Representation for EN 010137

Rebecca Face affected party 20048555

I am writing to expand on my initial objection to the Mona offshore wind farm project.

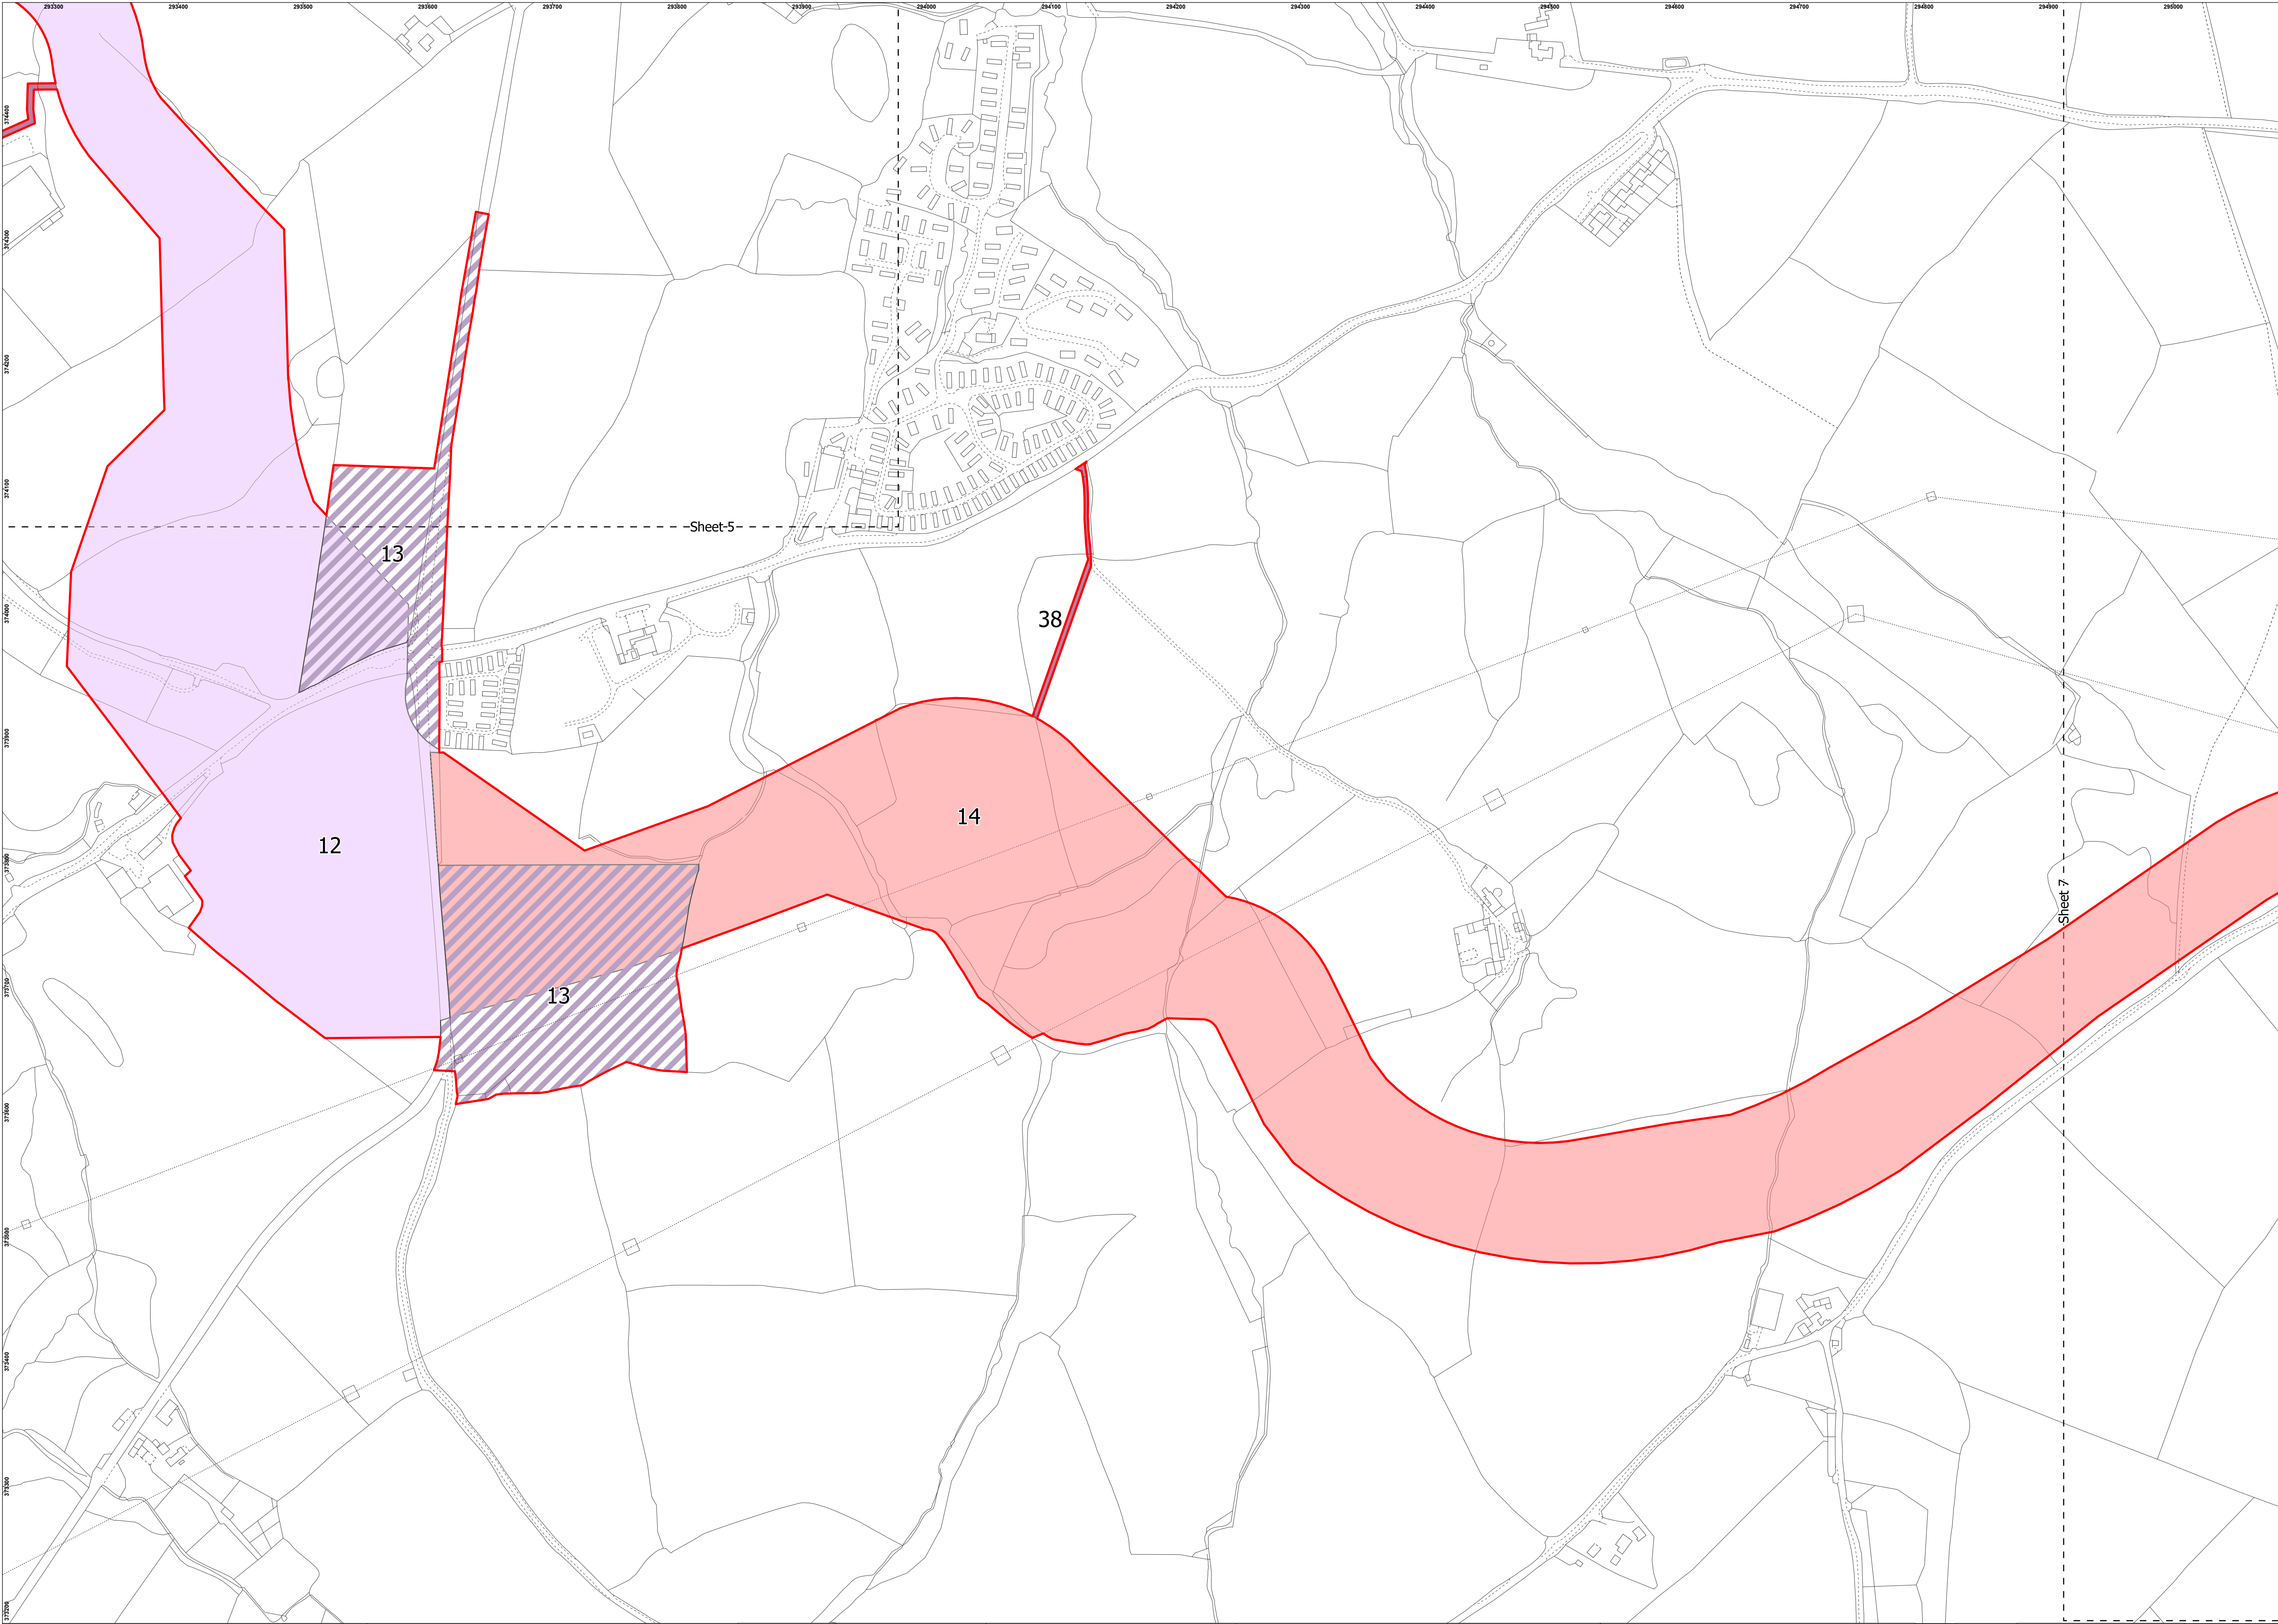
The problem with the application is that they want to drill holes through the fractuous bed rock that the springs rise through, (see picture 2 for the cable route stated in the application and the cable route stated verbally). Any digging or drilling in this area will guarantee the movement of these springs. As with all springs, there is no underground mapping for the fractures that the water is travelling through. The applicant cannot avoid the fractures as they do not know where they are. They are unavoidable. Any disturbance of the ground in proximity to these springs will cause the crumbly fractures to shift and alter the pressures. The water will change track, it is unavoidable, uncontrollable and once it has moved it is irreparable. Any attempt to "repair" the damage or move it in a specific direction will simply result in further movement and damage.

This problem, and the following problems, can all be resolved by simply narrowing the corridor to keep all the cable trenches within 100m of the A548. This will give the applicant the max work area that they say they need and will give the springs the max possible buffer to prevent damage.

During my discussions with the applicant, the only reason they have ever given me for the extra width that they're asking for at this location, is that they want to avoid a "hard bend". The angles of turn between TCC2 and TCC3 are 29 degrees and 55.5 degrees (see picture 3). This is a very gentle sweeping curve which will not be altered by reducing the width of the corridor. This is in comparison to a 96.5 degree bend followed by a 68 degree bend on works plan onshore sheet 10, (see picture 4) and an 100 degree bend on sheet 7, where the corridor appears to be at its minimum width of 74 m, (see picture 5).
